### CLITHEROE TOWN COUNCIL

8 May 2012

3/2012/0277

PROPOSED SITE PLAN 1:250

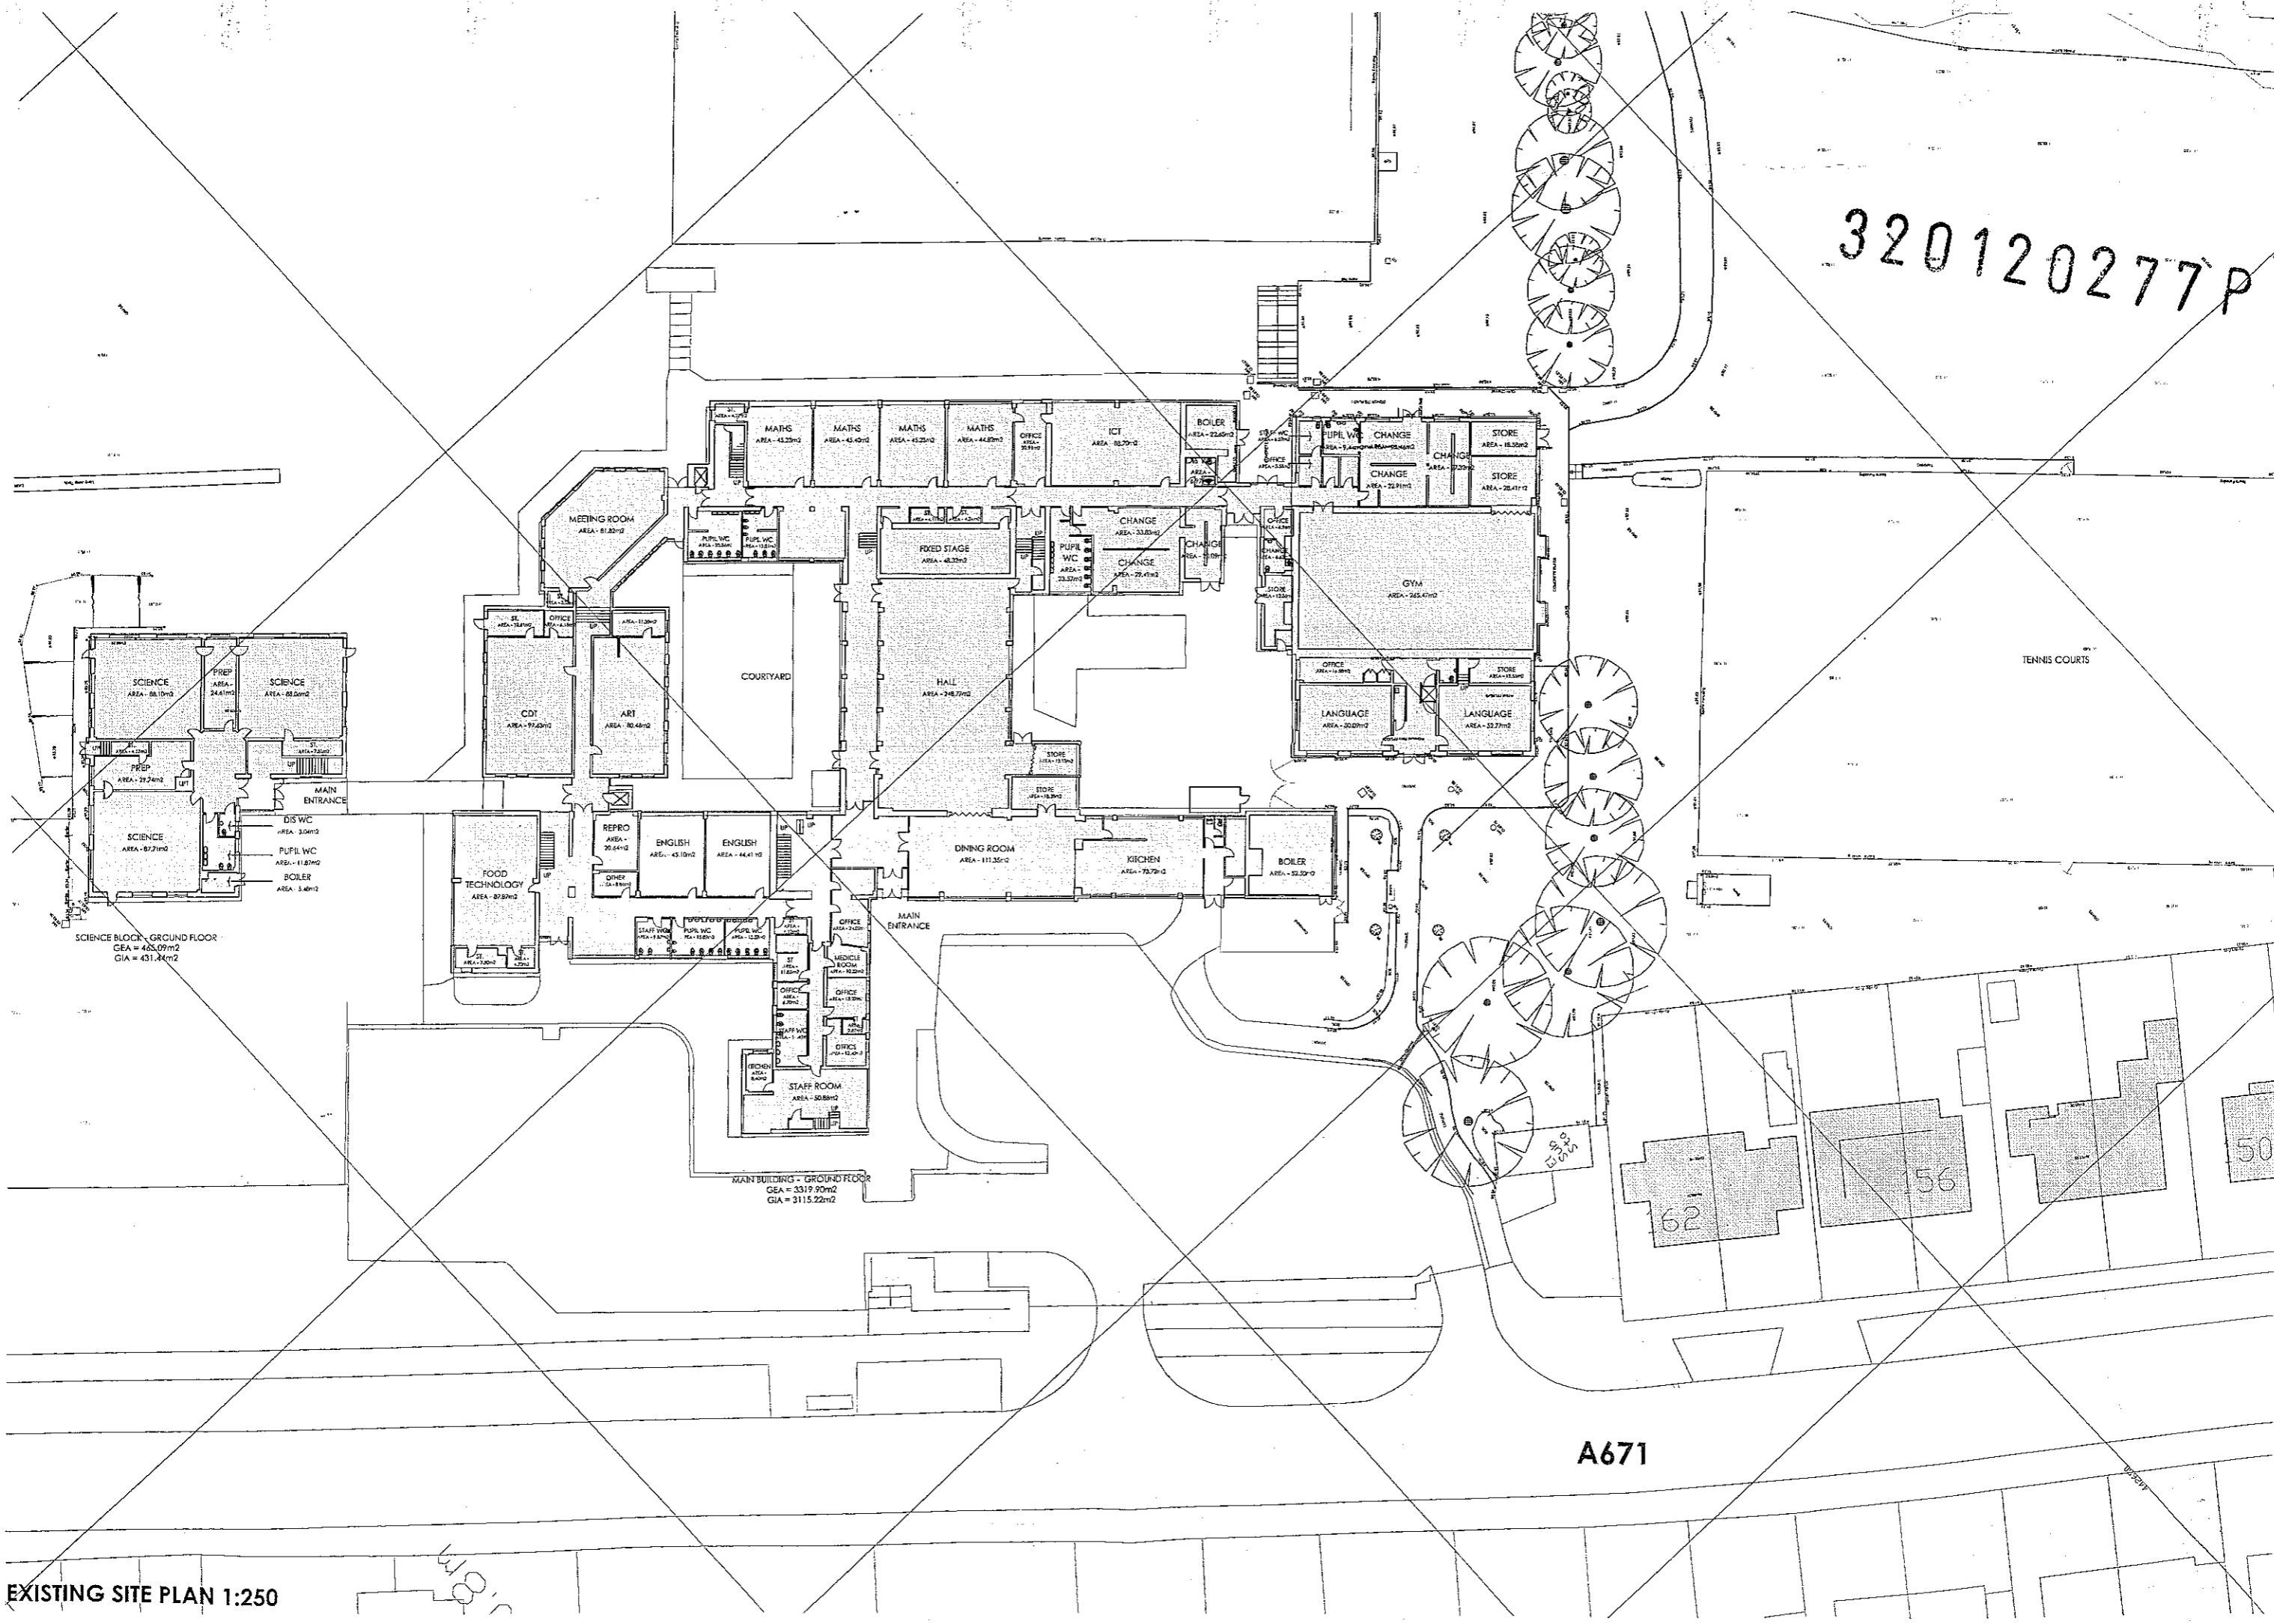
- The development will be detrimental to residential amenity as the new sports hall will be located too close to the nearby residential properties
- That a time limit be placed on the use of the floodlights on the tennis courts to prevent nuisance being caused to local residents in an evening.
- That before any development takes place remedial action be carried out to address potential flooding
